**Land Adj to B4035 CTIL 201348  
Unnamed B4035 Single Carriageway 6811256  
Sibford Gower**

**18/00016/NMA**

**Application Description:** Non Material Amendment to 16/02150/F – The proposal is that the 21m lattice tower will only have 3 antennas attached initially, rather than the 6 approved.

Drawing Title:
PROPOSED SOUTH EAST ELEVATION

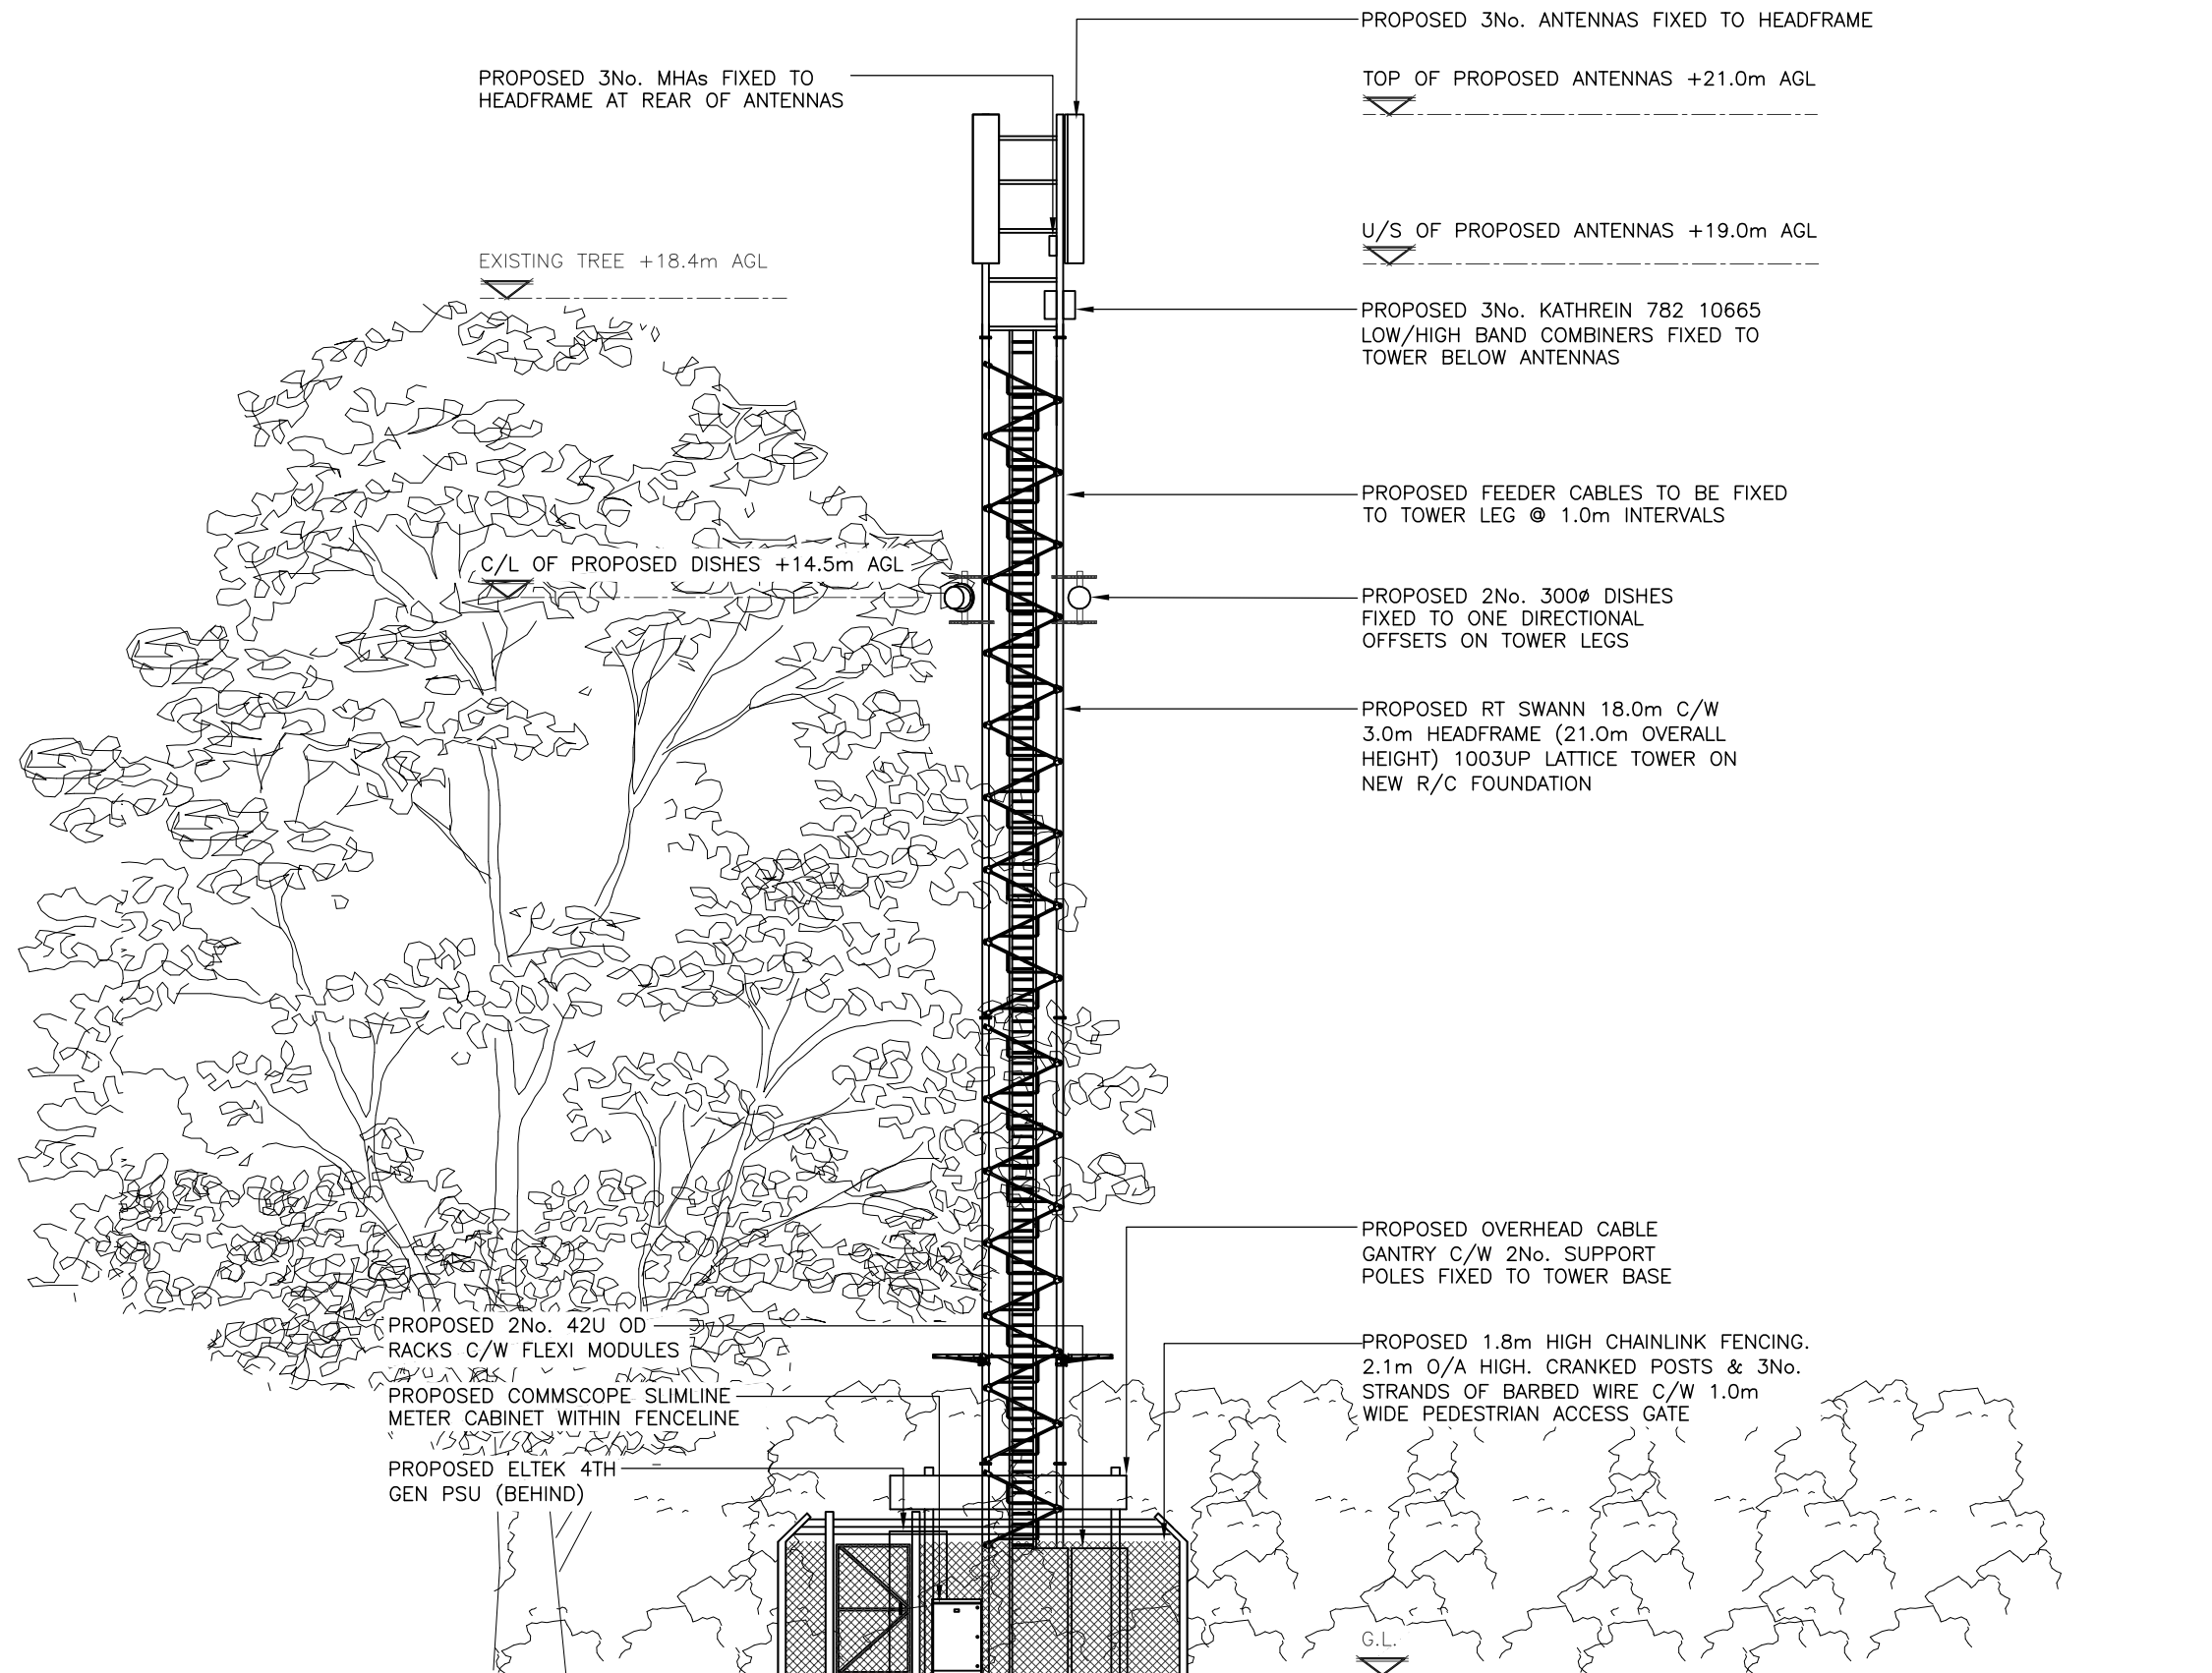
This Non-Material Amendment application proposes to reduce the number of antennas to 3 from the approved scheme which had 6.

It is considered that the proposed changes would be non-material. The alterations would not affect the character of the permission in any way and would be removing elements from the scheme that do not have a material impact.
